Our Case Number: ABP-314597-22

Re: BusConnects Galway Cross-City Link Scheme.
University Road to Dublin Road, Galway City.

Objection / Observation :

This is an objection and observation in relation to the *BusConnects Galway: Cross-City Link (University Road to Dublin Road) Scheme*, details found at <https://www.crosscitylinkgalway.ie/>.

Role	Transport Infrastructure
Suitability	Planning
Arup Job No	253352-00
Name	BCG-GA-00-01
Rev	PL01

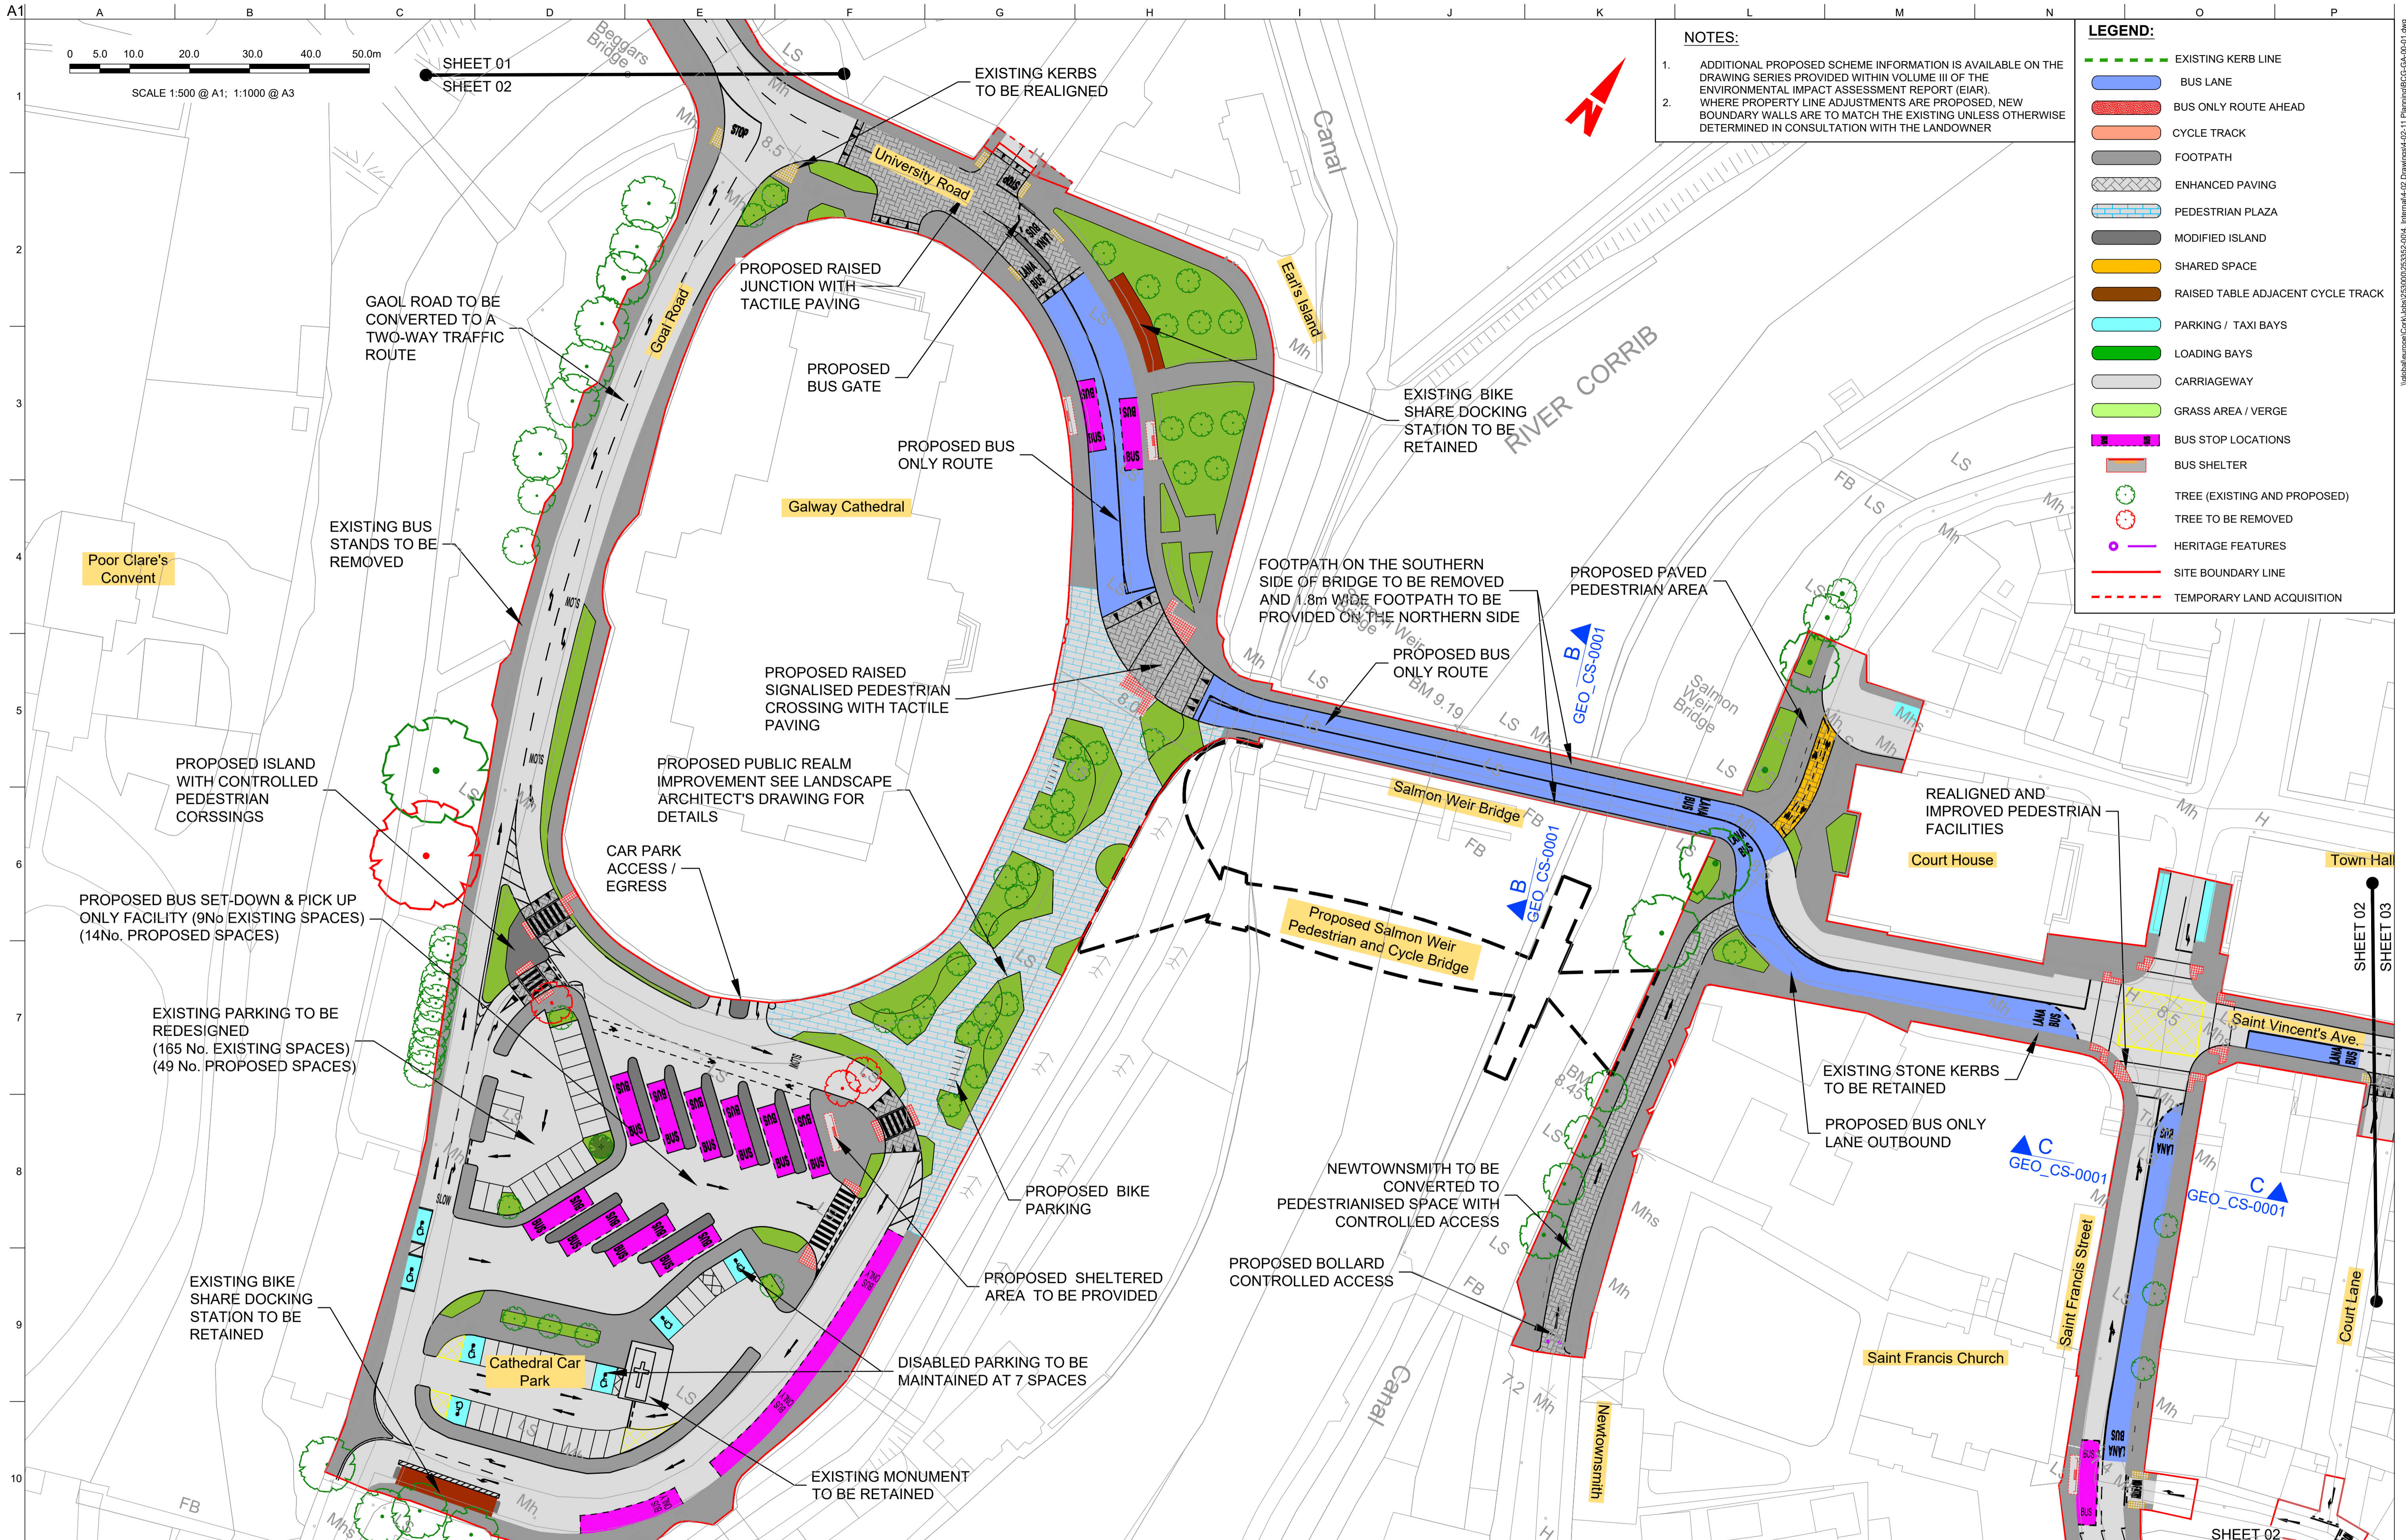
After reading, Section 4.6.2.3 of Chapter 4 - "proposed scheme description", for the Bus Connects project in Galway City. We, a select group of residents from University Road, wish to OBJECT to construction of a bus shelter as detailed in Table 4.6 on page 38 of Chapter 4 - "proposed scheme description" (found here <https://www.crosscitylinkgalway.ie/environmental-impact-assessment-report/> under Volume 4.).

This table says that the current west bound bus stop (NUIG main gate - No. 523031) is to be retained and a "bus shelter with seating" is to be added to it. This bus stop is located at the entrance to numbers 8 and 9 university road. **We wish to object to this on the following grounds:**

1. The current bus stop is impeding access to the driveway at Numbers 7, 8 and 9 when large crowds gather and buses stop there. There are often large queues of students, or parents and children clustered at the driveway entrance to numbers 7, 8 & 9. Entering and exiting with a car is often requires stopping to allow pedestrians to move out of the way thus causing stoppages for the traffic on University road. Please see Figures 1 and 2 for an example of crowds and car exiting (best viewed in colour). Construction of a bus shelter would only serve to exacerbate the existing problem, and potentially cause a blind spot for drivers unable to see people.

1. The existing bus stop on the residents side of university road (NUIG main gate - No. 523031) is moved to a new location that does not interfere with residents for the reasons cited above.
